Development Facilitation Team (DFT) – Review Comments

DRB Project No: PR-2020-003484 Date: 10/11/2023 Agenda Item: #7 Zone Atlas Page: E-10

Legal Description: Lots 2 & 3 Block 12 unit 3, Volcano Cliffs SUBD

Application For: SD-2023-00048 – PRELIMINARY PLAT (DHO)

CITY OF ALBUQUERQUE
 PUBLIC WORKS DEPARTMENT
 ENGINEERING DEVELOPMENT GROUP
MOJAVE SUBDIVISION
 GRADING AND DRAINAGE
 GRADING PLAN

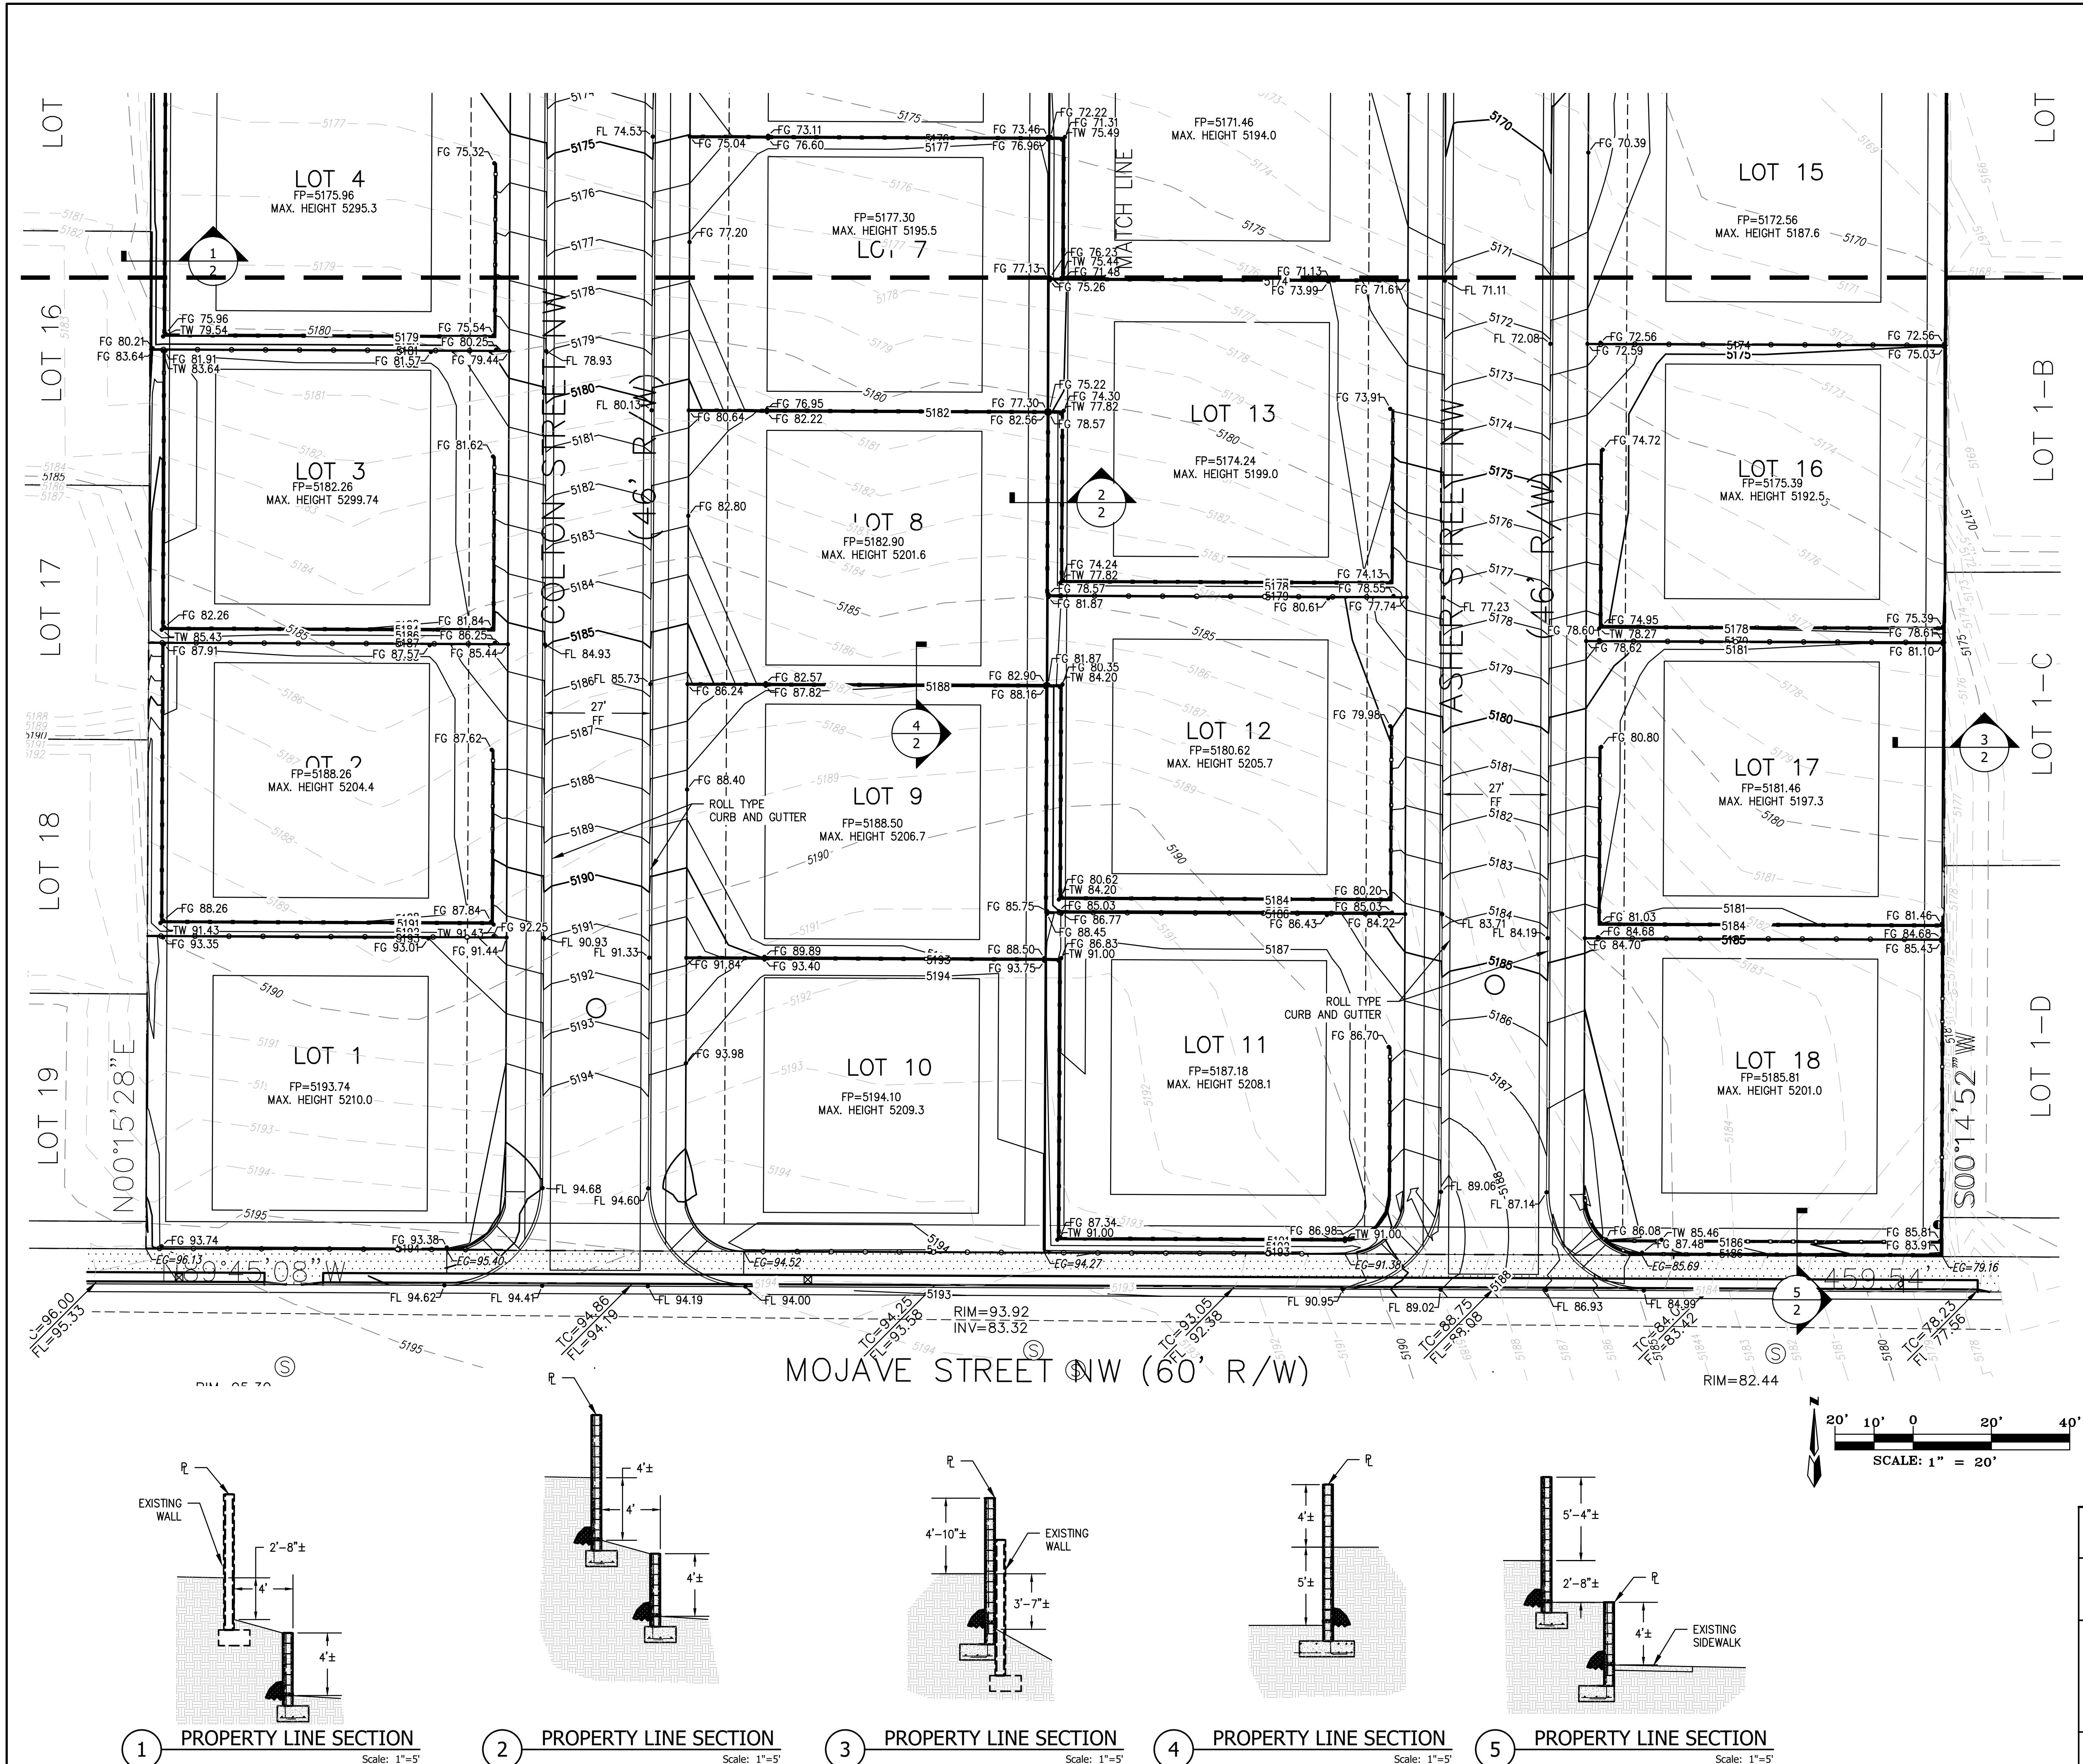
- Hydrology has an approved Revised Grading & Drainage Plans (E10D024) with engineer's stamp date of 05/15/23.
- Hydrology needs approvals from National Parks and Open Space.

PRELIMINARY PLAT FOR  
**MOJAVE RIDGE SUBDIVISION**  
 (A REPLAT OF LOTS 2 & 3, BLOCK 12,  
 UNIT 3, VOLCANO CLIFFS SUBDIVISION)  
 WITHIN  
 SECTION 27,  
 TOWNSHIP 11 NORTH, RANGE 2 EAST, N.M.P.M.  
 CITY OF ALBUQUERQUE  
 BERNALILLO COUNTY, NEW MEXICO  
 JANUARY, 2023

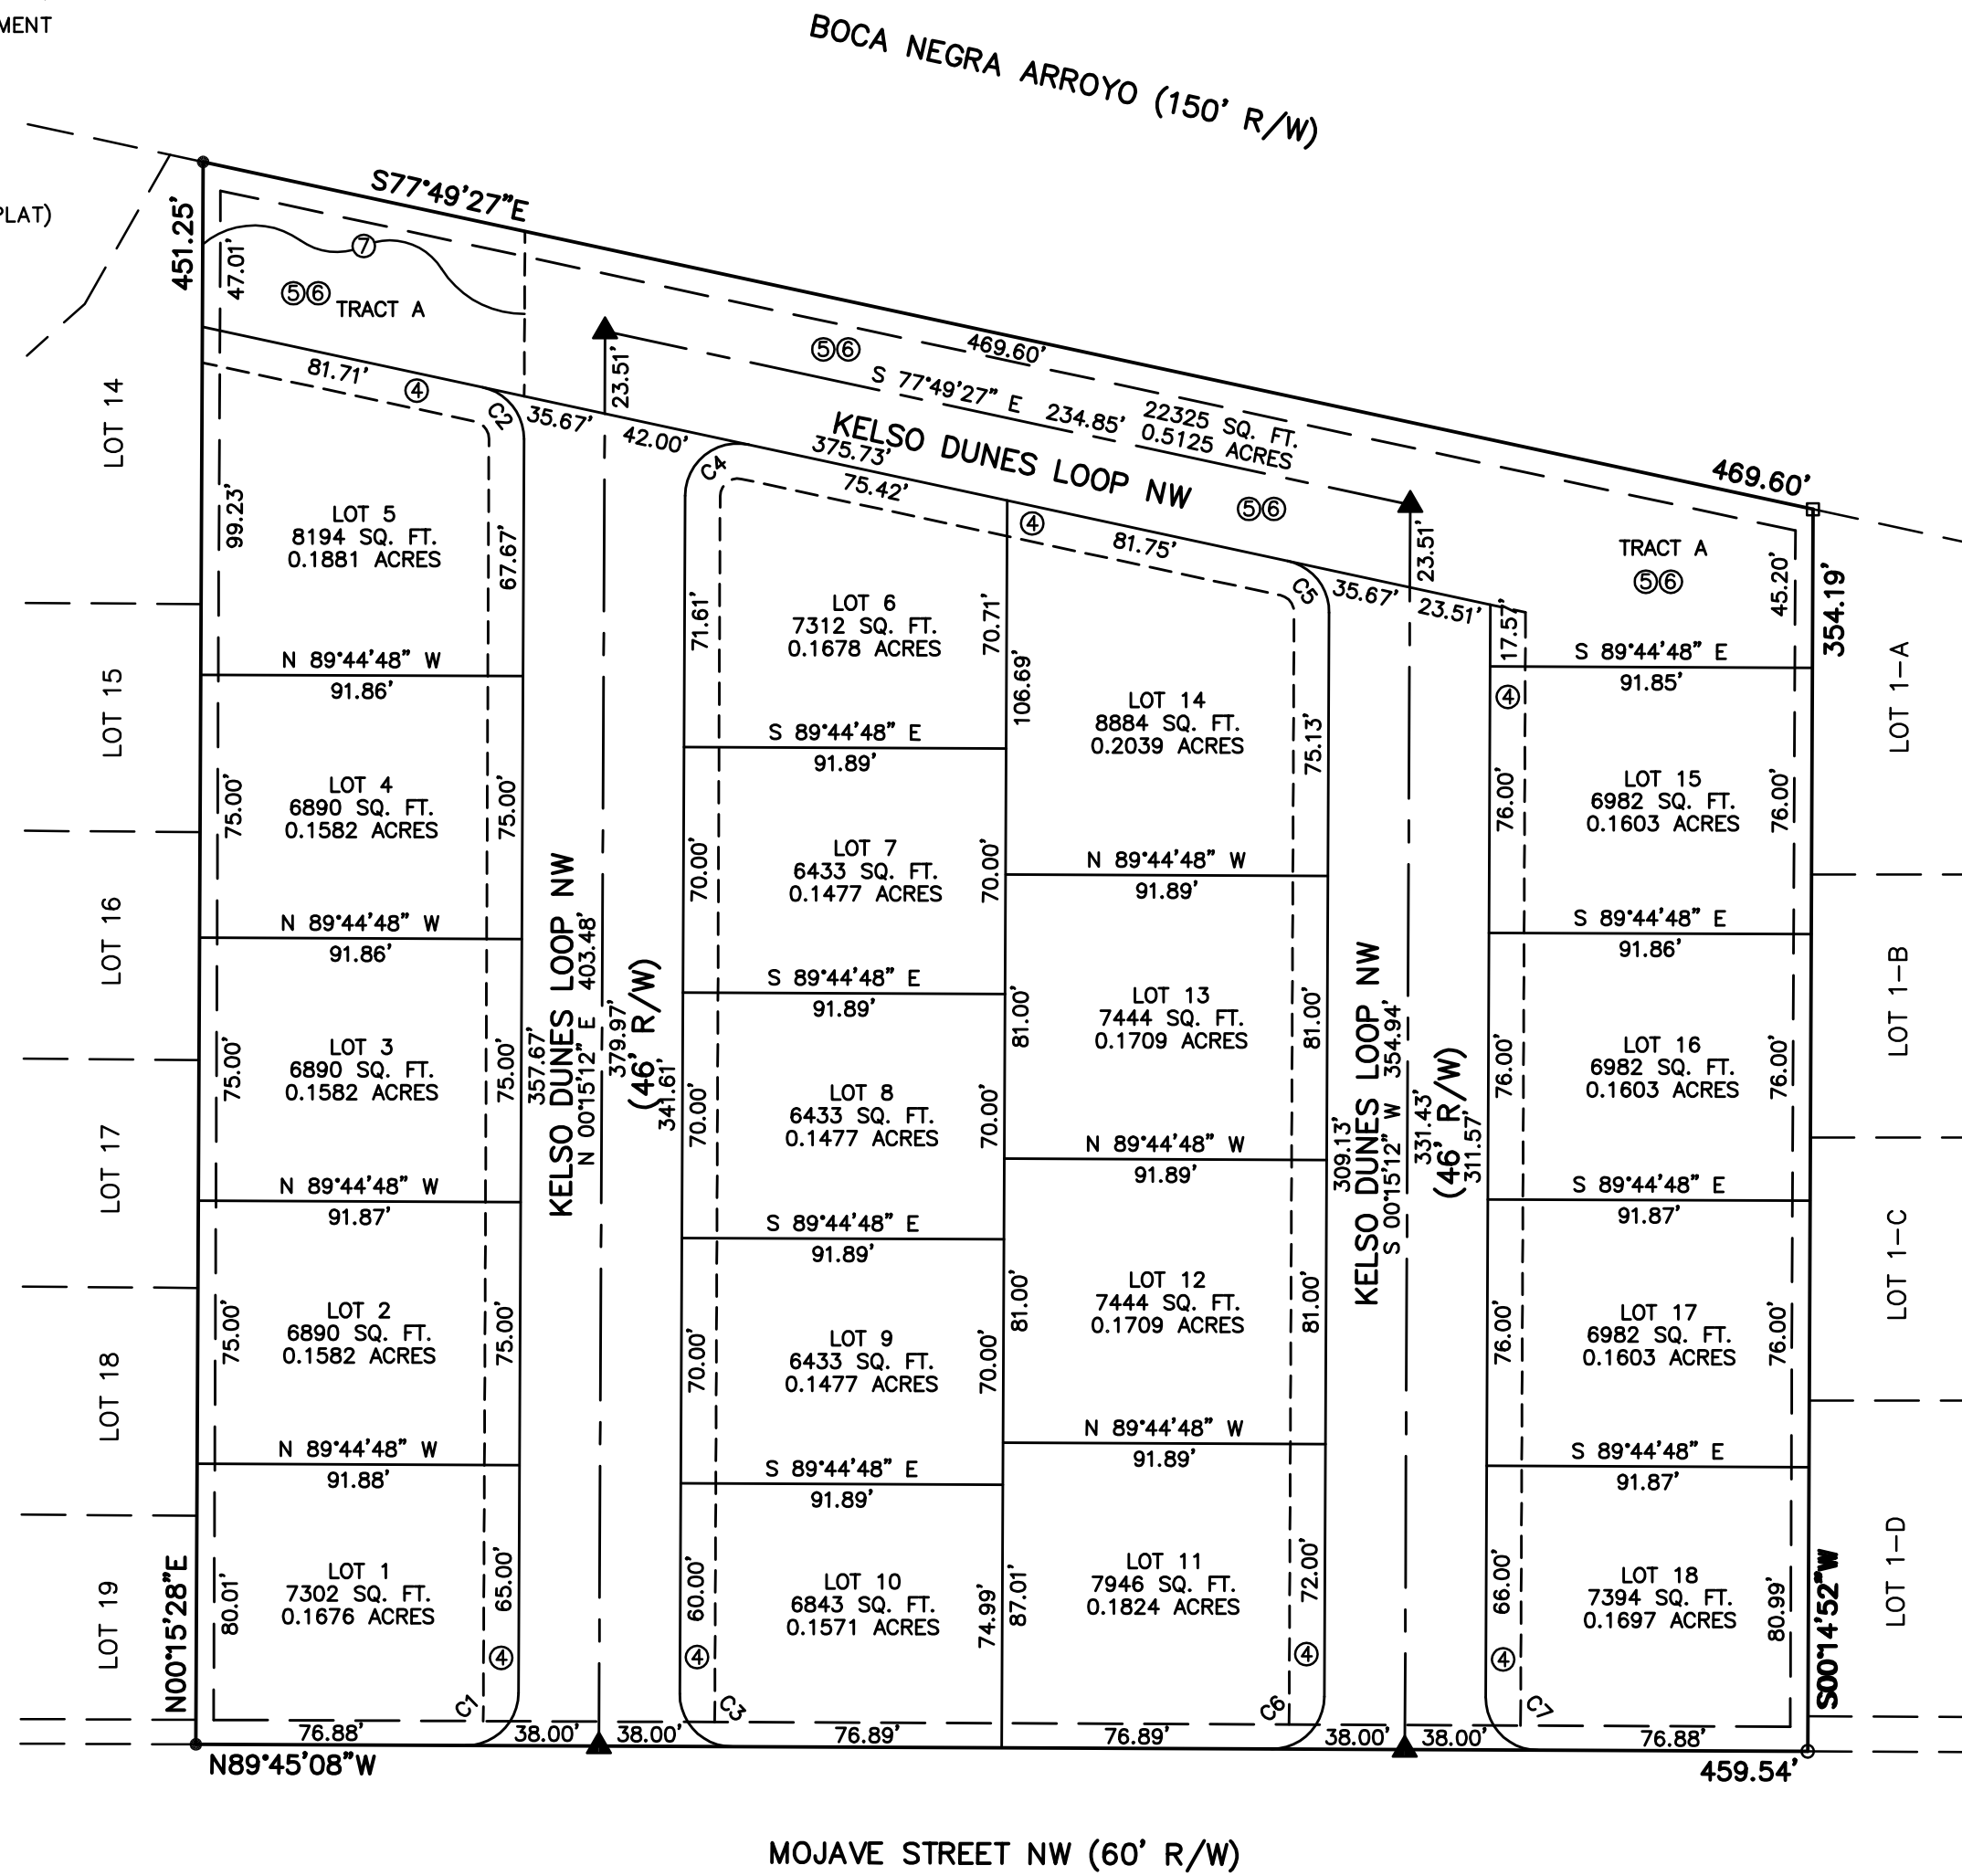
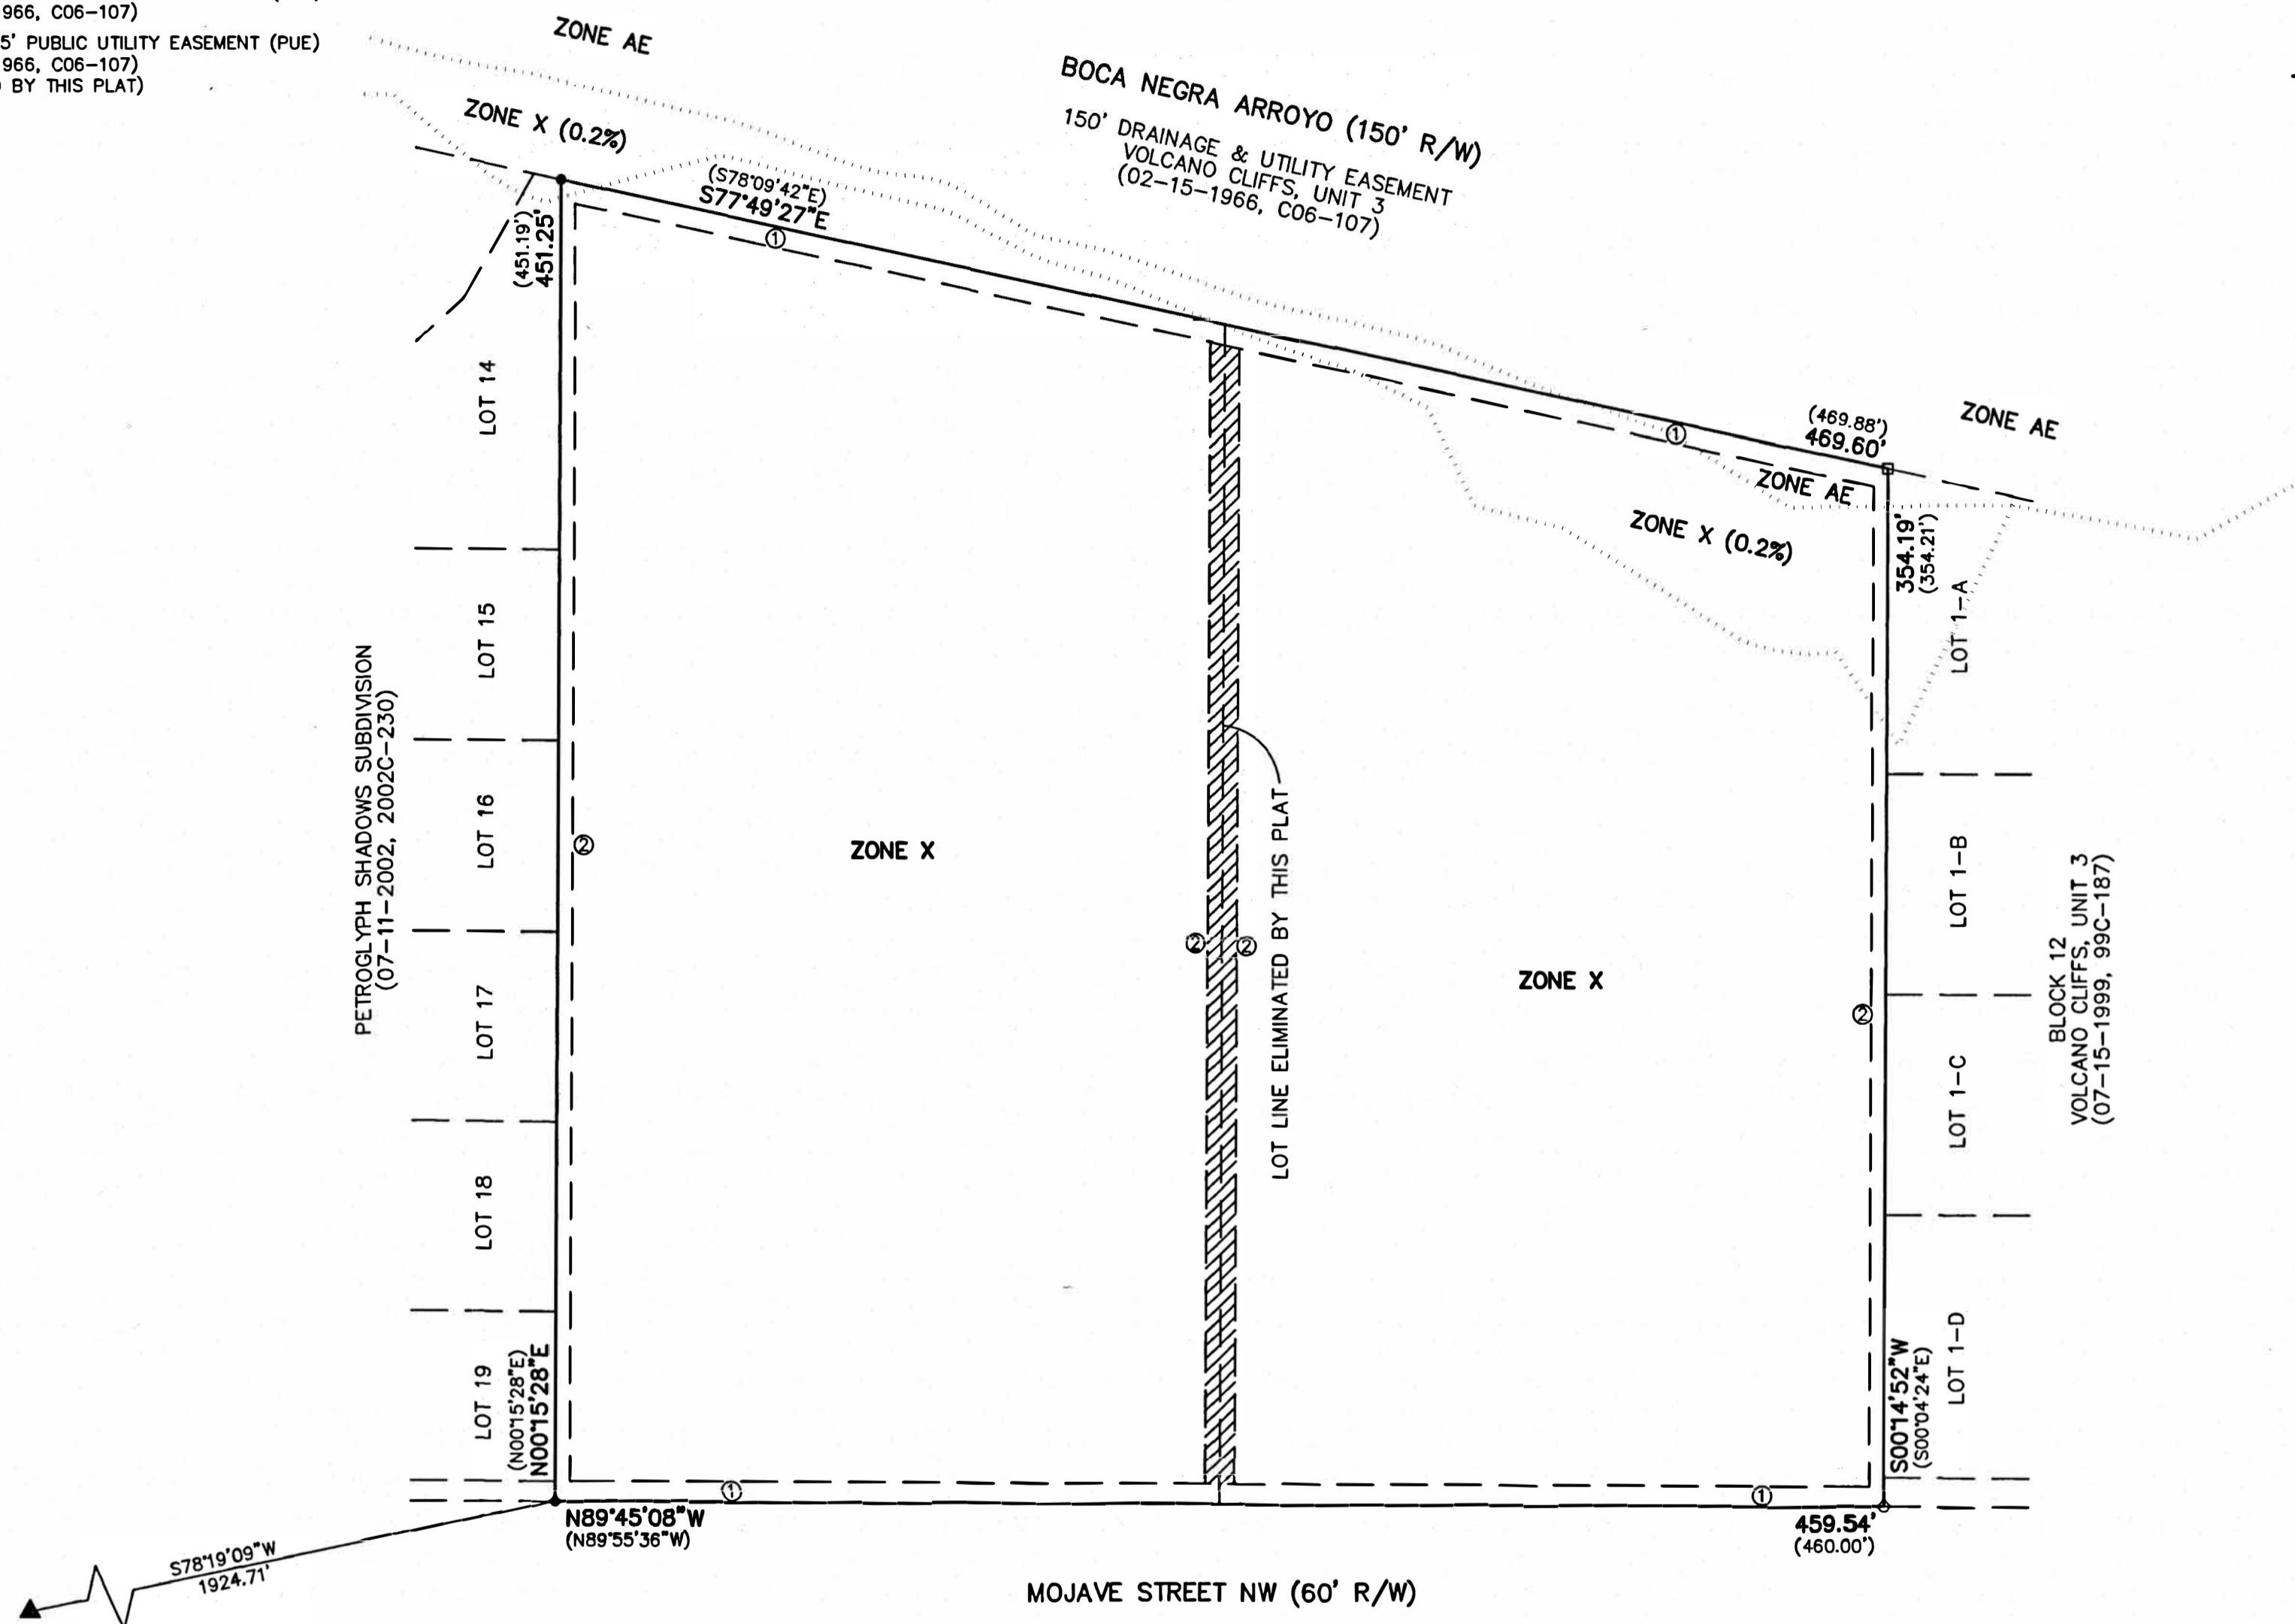
Updated 6.23.23 Change the maintenance note of Tract A (pond) to be the Homeowner's Association, not just 'owner'; city maintenance is not provided for Tract A. The landscape buffer in the northwest corner of the subdivision should be in a separate tract with a note as shown on the next page.

- **Updated 10.11.23** 5-2 (J)(2)(a) Lot 5 is abutting the Boca Negra arroyo. Add a note to the plat indicating that the 45 feet buffer abutting the Petroglyph National Monument must have plant approval and location per the Open Space Superintendent.
